ATTACHMENT E - RESPONSE TO OFFICE OF ENVIRONMENT & HERITAGE SUBMISSION

Issues & Recommendations	Response
Office of Environment & Heritage	
Biodiversity values of the site The proposal seeks to remove Cumberland Plain Woodland (CPW) which is listed as a critically endangered ecological community (CEEC) under the NSW Biodiversity Conservation Act 2016 (BC Act). It is also listed as CEEC for the related community of Cumberland Plain Shale Woodlands and Shale-Gravel Transition Forest, under the Commonwealth Environment Protection and Biodiversity Conservation Act 1999 (EPBC Act).	Noted.
Cumberland Plain Woodland is currently listed as a Serious and Irreversible Impacts entity as it is most at risk of extinction from potential development and therefore must be protected. In the Sydney Basin, 93% of this critically endangered ecological community has already been cleared and very little of this community remains within a 1,000 ha and 10,000 ha radius of the site (refer to Figure 1 in Attachment 2).	Noted.

drg title	
SITE PLAN	
drawn	checked
SB	RD

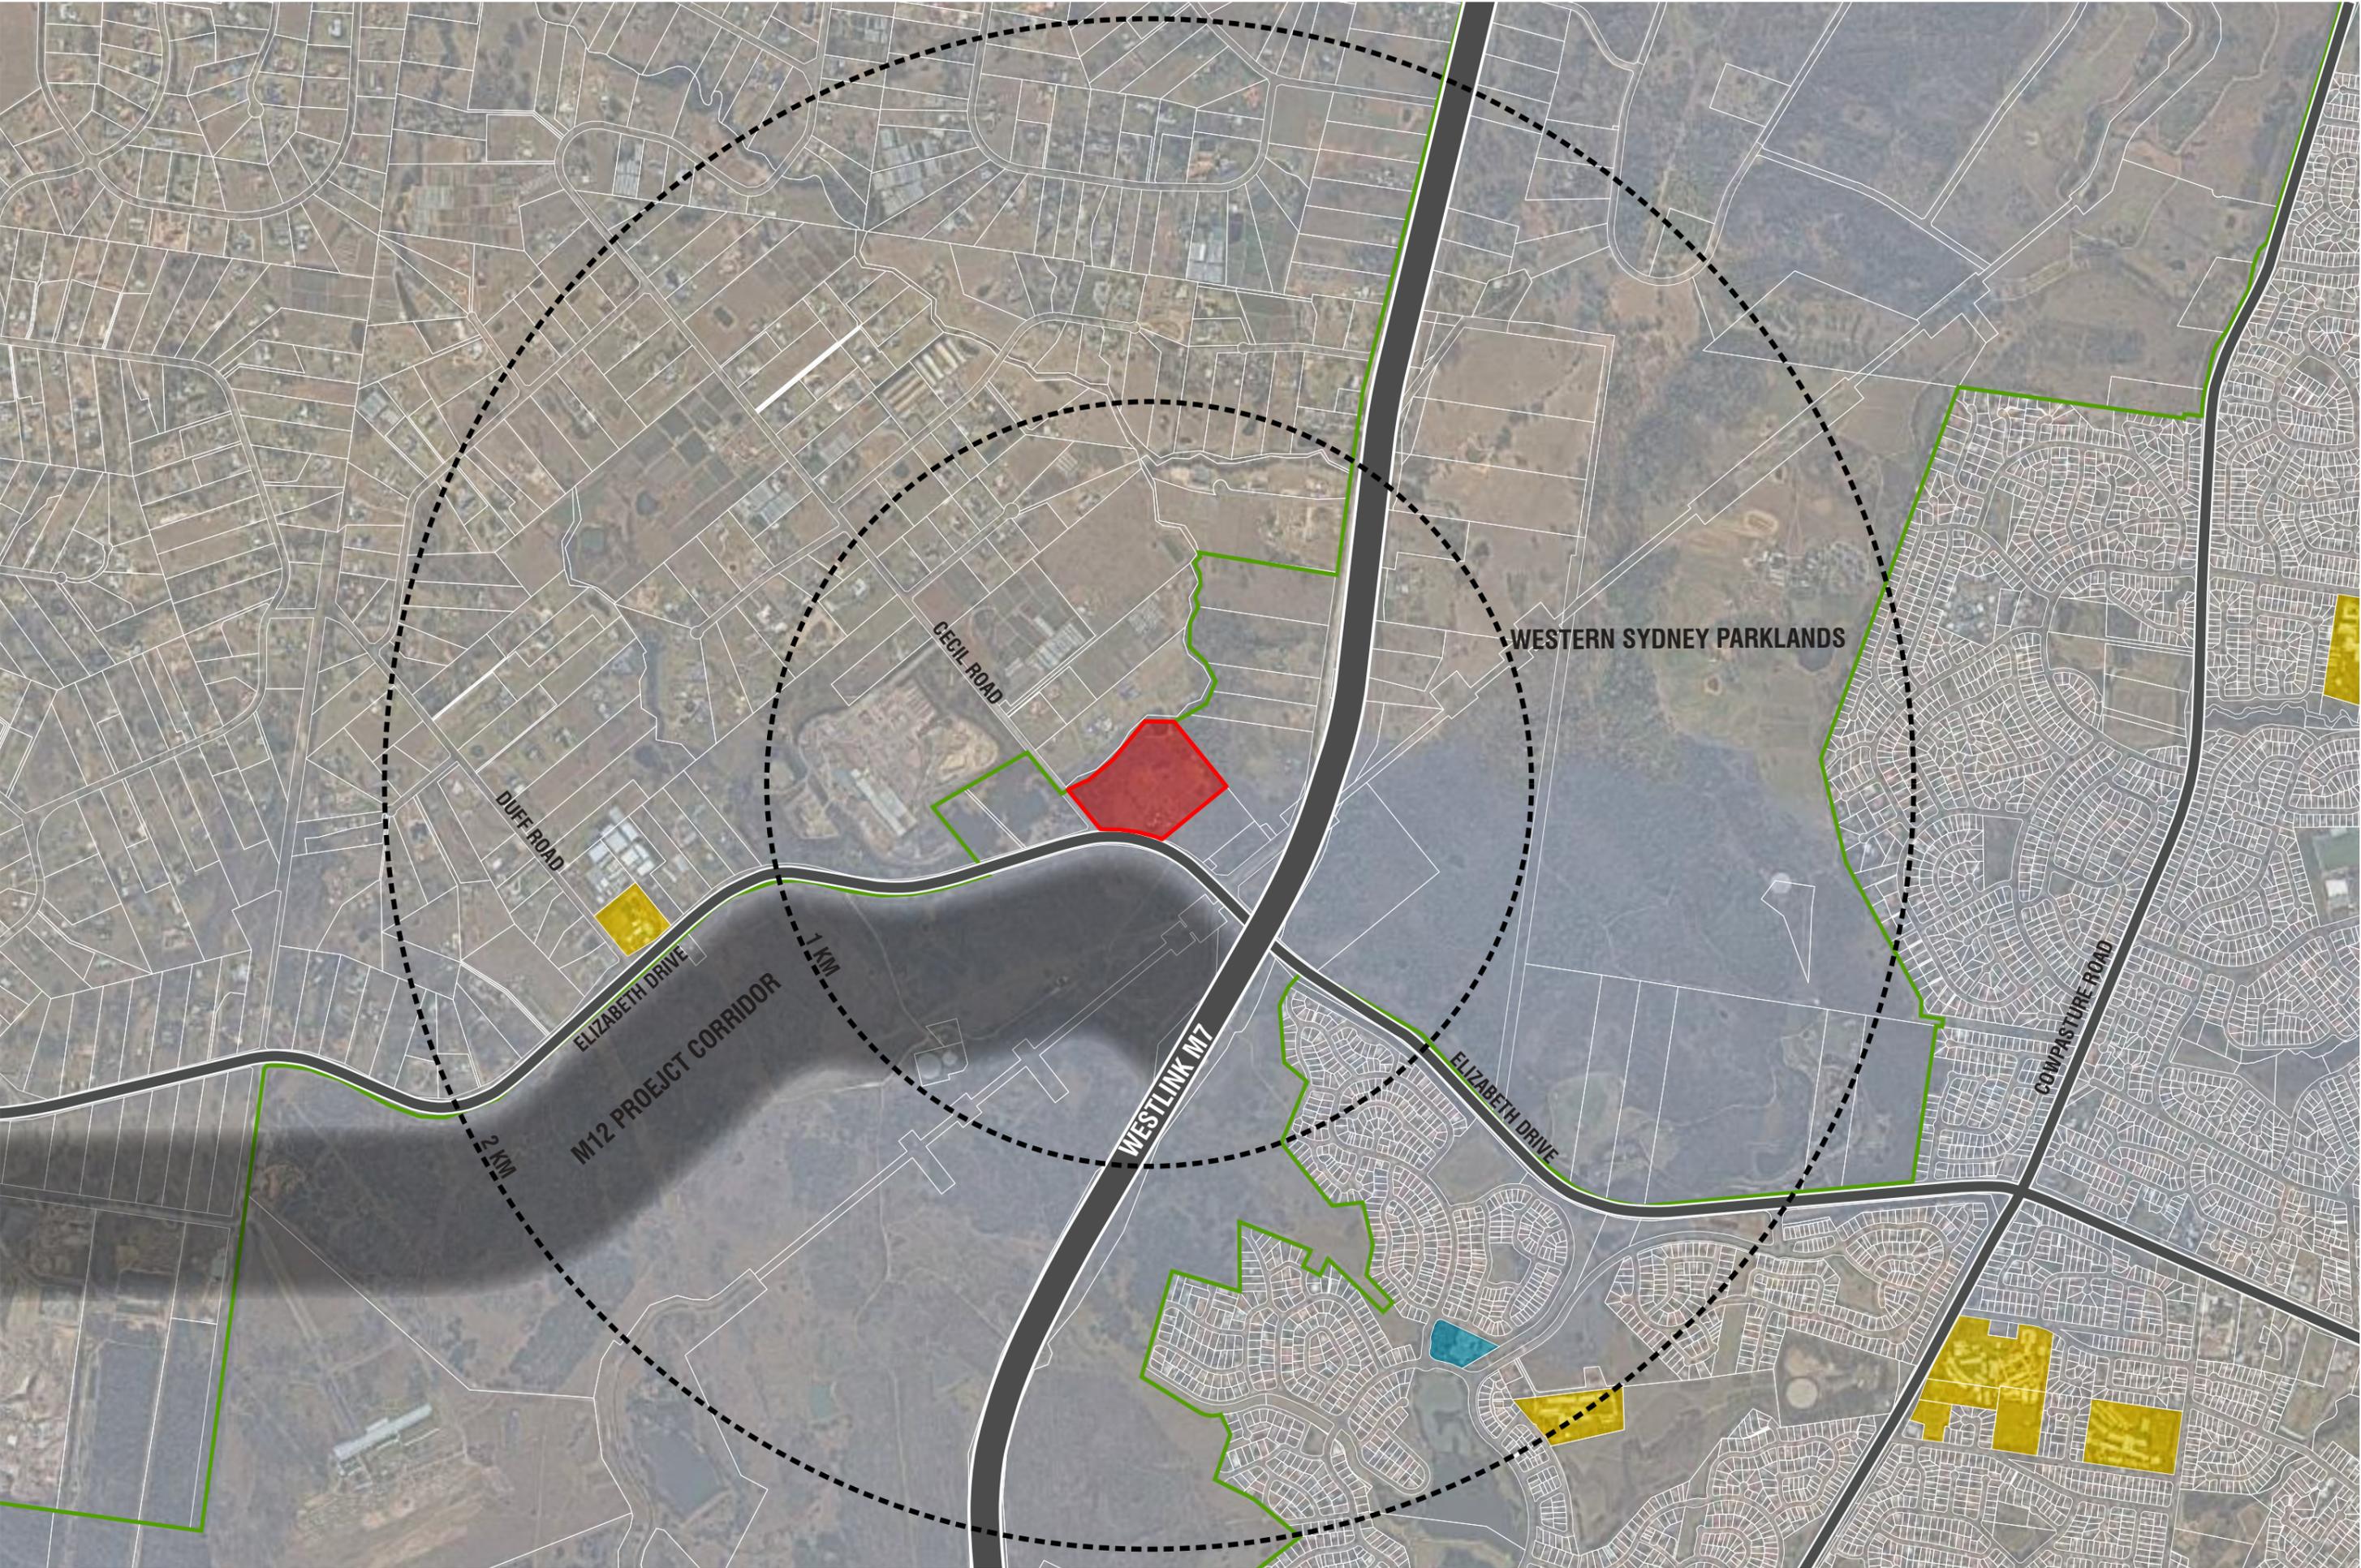
The urban design report states "Due to the site's area of 7.38 ha, there is limited scope for retention of extensive vegetation which should not result in any reduction of the size of the development footprint". This statement demonstrates that limited site analysis has occurred with the view to avoid impacts on significantly threatened and in this case critically endangered ecological community. OEH considers that adequate

planning/siting of the proposal has not been carried out that avoids the CPW. The site is 7.37 ha in size with a proposed developable footprint of 6.01ha although there is a cleared area of 3.66 ha comprising exotic vegetation on site.

The BDAR states (page 32 Chapter 5.2 -Avoidance of Impacts) "The proposal has aimed to avoid impacts on native vegetation and habitat values by focusing development in areas of exotic grassland where possible and adjusting the proposal footprint to limit impacts on better quality vegetation within the remainder of the site (see BDAR Figure 5)." However, only one vegetation zone was identified across the study area (see BDAR Figure 4), which shows the vegetation was considered homogeneous across the site. Therefore, the proposal does not limit impacts on 'better quality' vegetation because the vegetation was assessed as having a relatively homogenous condition (or 'quality') across the entire study area. OEH considers that through better site planning that the CPW_on site can be protected and retained.

The proposal has aimed to avoid impacts on native vegetation and habitat values by focusing development in areas of exotic grassland where possible, and adjusting the proposal footprint to limit impacts on better quality (i.e. native) vegetation within the remainder of the site (see Figure 5-1). The proposal includes 11 industrial lots that would result in impacts to 1.15 ha of native vegetation. The current footprint represents a third iteration of the proposal, and was devised following ongoing consultation with DPIE regarding the need to avoid impacts on the CEEC Cumberland Plain Woodland (PCT 849), as well as consultation with TfNSW regarding compulsory acquisition of a portion of the lot.

The original proposal sought to impact 2.35 ha of PCT 849 (GHD 2018). This amount was reduced to 2.00 ha in October 2019 following consultation with DPIE on an acceptable quantum of impacts. This amount has been further reduced to 1.15 ha in the current BDAR, taking into account the constraints associated with the proposed land acquisition for the M12 Motorway, while still achieving a viable development
